CITY OF ALBUQUERQUE

Re: Central & Unser Transit
8021 Central Ave NW
Traffic Circulation Layout
Engineer's Stamp 04-07-17 (K10-D053)

Based upon the information provided in your submittal received 04-07-17, the above referenced plan cannot be approved for Building Permit until the following comments are addressed:

## SOUTHWEST MESA PARK & RIDE SITE PLAN

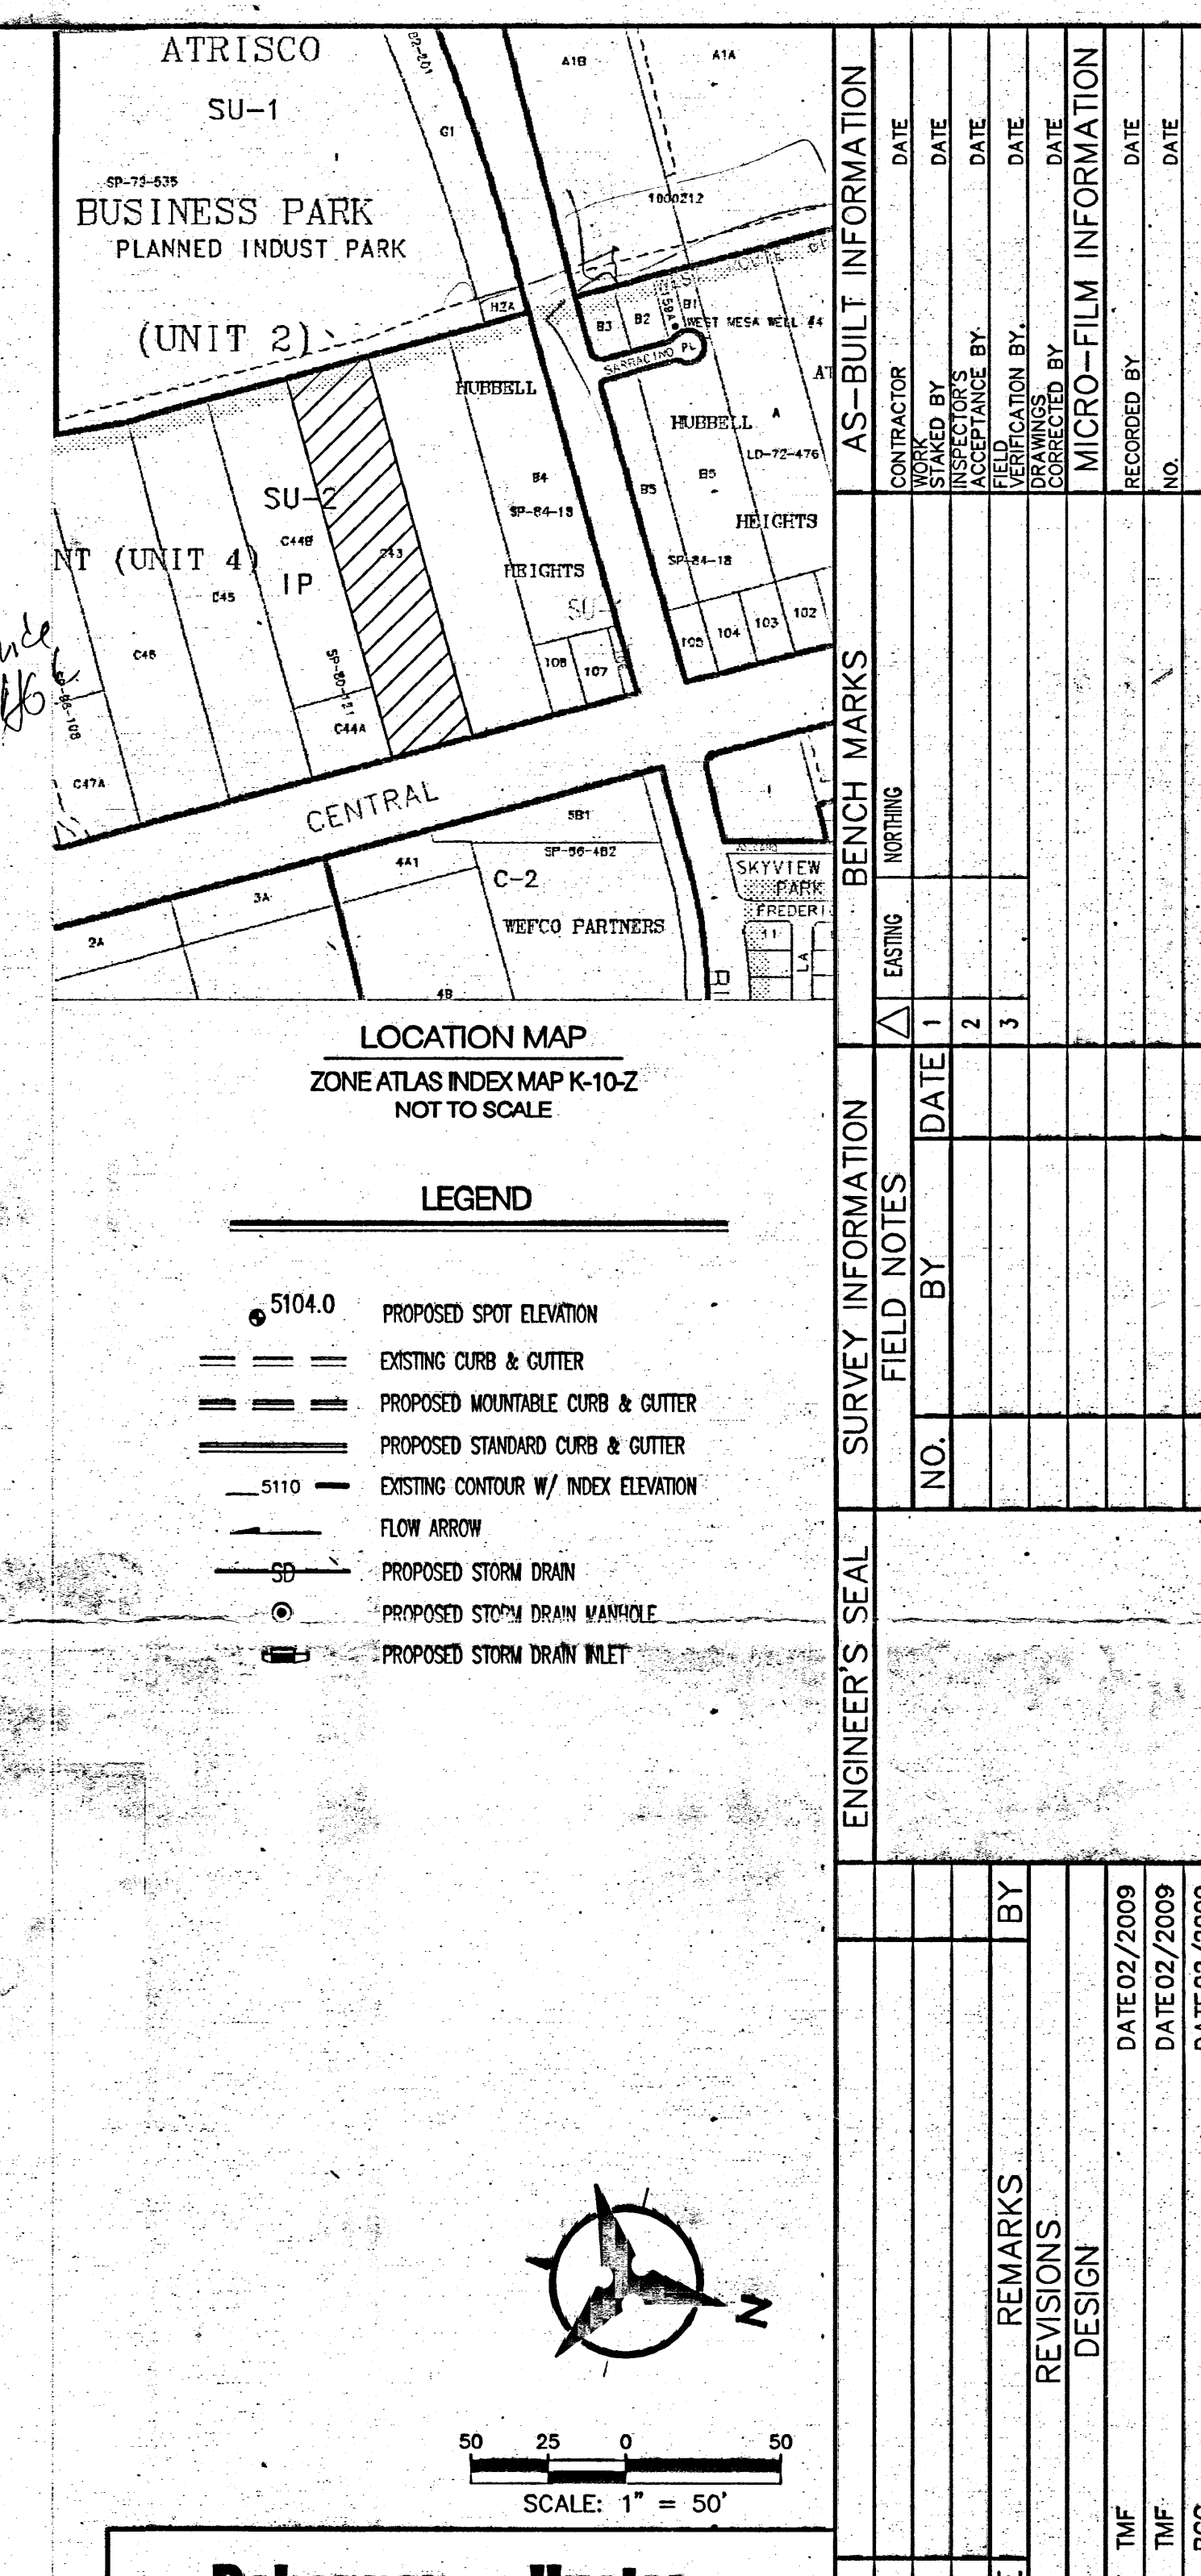
1. Please review and revise plan to provide all information listed on the attached Traffic Circulation Layout checklist.
2. Identify all existing access easements and rights of way width dimensions.

3. Please list the width and length for all existing and proposed parking spaces. Some dimensions are not shown.
4. The handicap accessible spaces must be a minimum of 8.5 ft. in width.

5. The handicap accessible spaces must include an access aisle. Van accessible aisles should be 8ft wide; all others should be 5ft wide.
6. The ADA accessible parking sign must have the required language per 66-7-352.4C NMSA 1978 **"Violators Are Subject to a Fine and/or Towing."** Please call out detail and location of HC signs.

7. The ADA access aisles shall have the words **"NO PARKING"** in capital letters, each of which shall be at least one foot high and at least two inches wide, placed at the rear of the parking space so as to be close to where an adjacent vehicle's rear tire would be placed. (66-1-4.1.B NMSA 1978)

8. The ADA parking space has a clearly visible, blue, International Symbol of Accessibility painted on the pavement at rear of the space (66-1-4.1.E NMSA 1978) or MUTCD recommends a white symbol on a blue background.

9. Please dimension all pedestrian path ways. Some dimensions are not shown. Provide ADA curb ramp detail if needed.
10. Show all drive aisle widths and radii. Some dimensions are not shown.

11. List radii for all curves shown; for passenger vehicles, the minimum end island radius for passenger vehicles is 15 ft. Radius for delivery trucks, fire trucks, etc. is 25 ft. or larger.

12. One-way vehicular paths require pavement directional signage and a posted **"Do Not Enter"** sign at the point of egress. Please show detail and location of posted signs.
